**Our ref:** NE/2021/133616/01-L01  
**Your ref:** 6/2021/2260/FULL  
**Date:** 9 September 2021

**Shell Welwyn Garden City Stanborough Road Welwyn Garden City, AL8 6XA.**

**Redevelopment of petrol station; including demolition of existing sales building, canopy link and car wash/jet washes, erection of a new sales building, provision of car parking spaces, provision of EV charging bays and associated plant, erection of a new bin store, retention of forecourt and canopy, and associated works.**

TITLE: PROPOSED SITE LAYOUT - 1:100

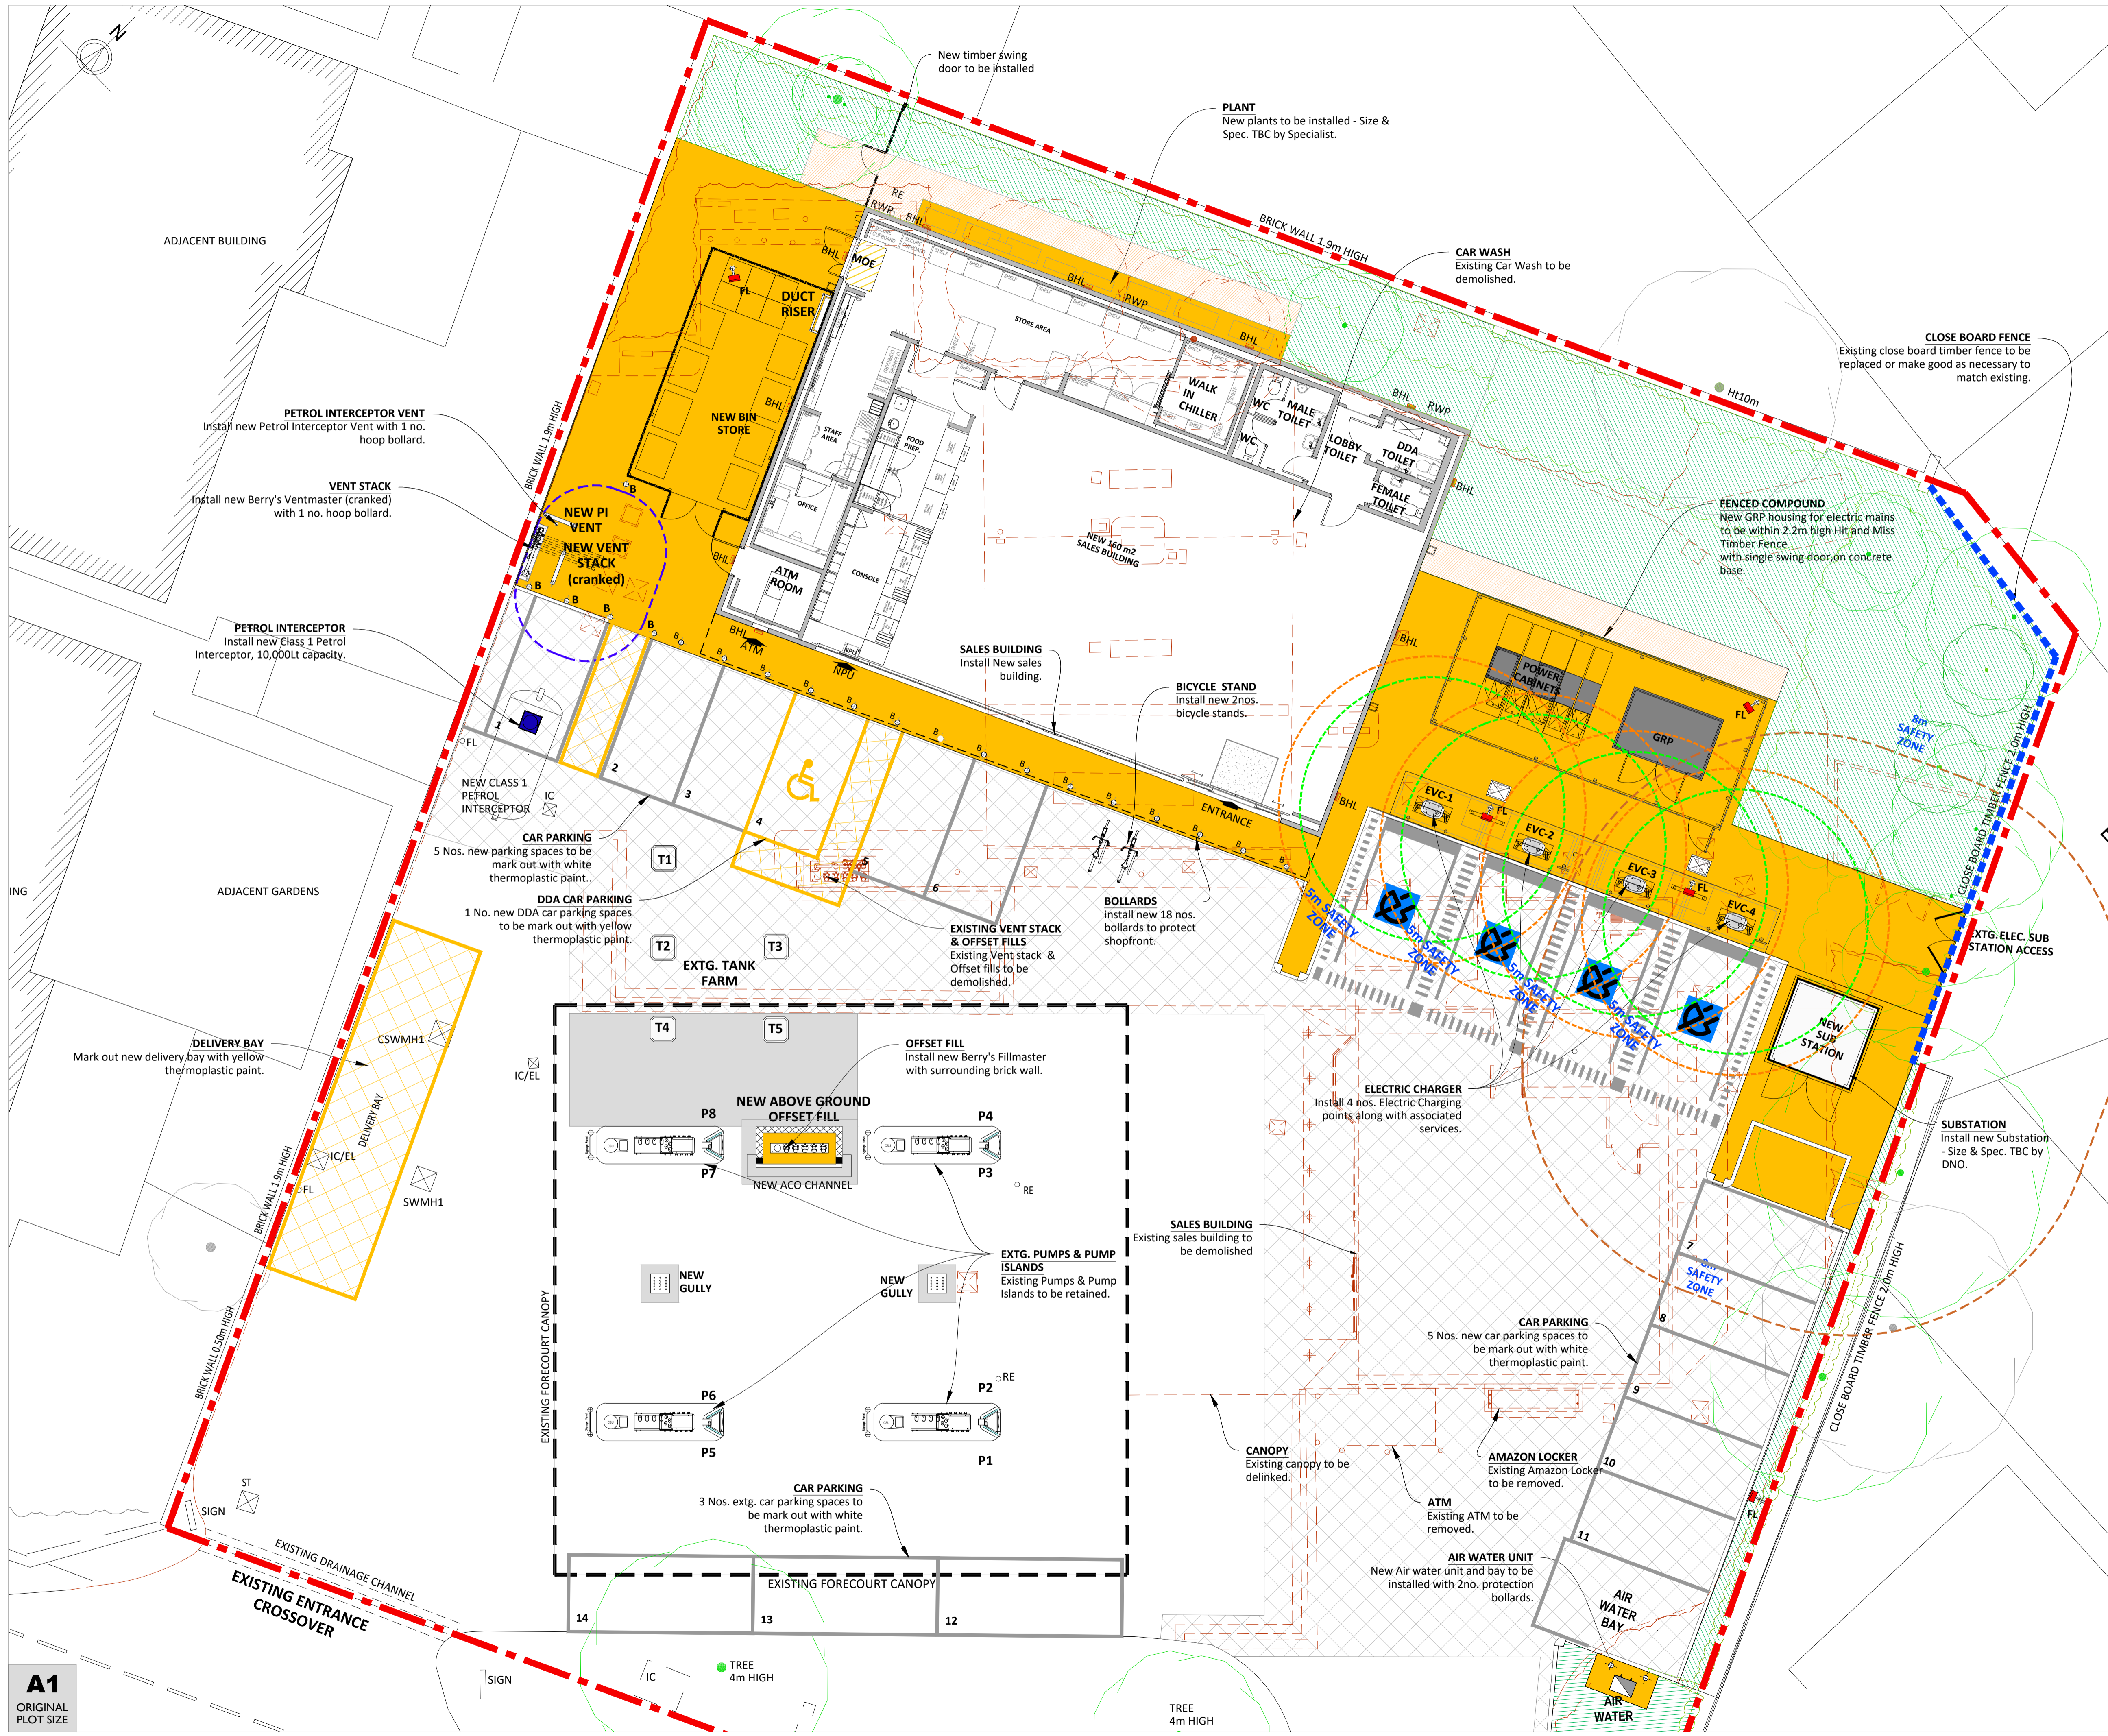
The document "*Proposed Site Layout*", drawing no. 12038629, indicates a new substation is proposed as part of the redevelopment proposals. We note that this has not been discussed in the Preliminary (Phase 1) site assessment report. As such, all potential on-site sources of contamination associated with the redevelopment have not been considered in the initial Conceptual Site Model (CSM).

The CSM outlined in Section 3 of the submitted Preliminary (Phase 1) site assessment report should be updated to include the proposed substation as a potential source of contamination, alongside discussion of possible contaminant pathways and risks to controlled waters receptors arising from the proposed substation.
